From: [Holly Duncan](#)
To: [Dusty Pilkington](#)
Cc: [Holly Myers](#)
Subject: RE: BL-16-00013 Mitchell
Date: Wednesday, September 21, 2016 10:52:40 AM

From: Dusty Pilkington
Sent: Tuesday, September 20, 2016 11:50 AM
To: Kelly Bacon; Holly Duncan; Holly Myers; Josh Hink; Lucas Huck; Keli Bender
Subject: BL-16-00013 Mitchell

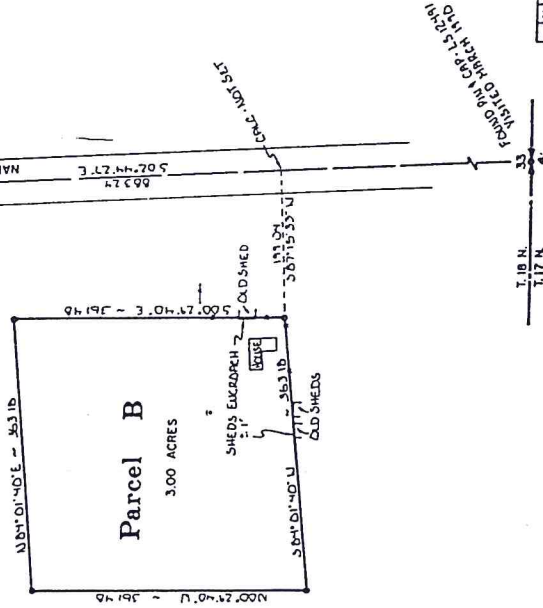
We need to know the distance that the well furthest to the west is from the proposed property line.

P.S. To Environmental Health: I understand that the site plan does not clearly show the distances from wells to the property lines, buildings, etc. I have informed the applicant that the application is complete for intake purposes, but a revision will be needed in order to make it to final processing. I thought I would get things rolling. Thanks!
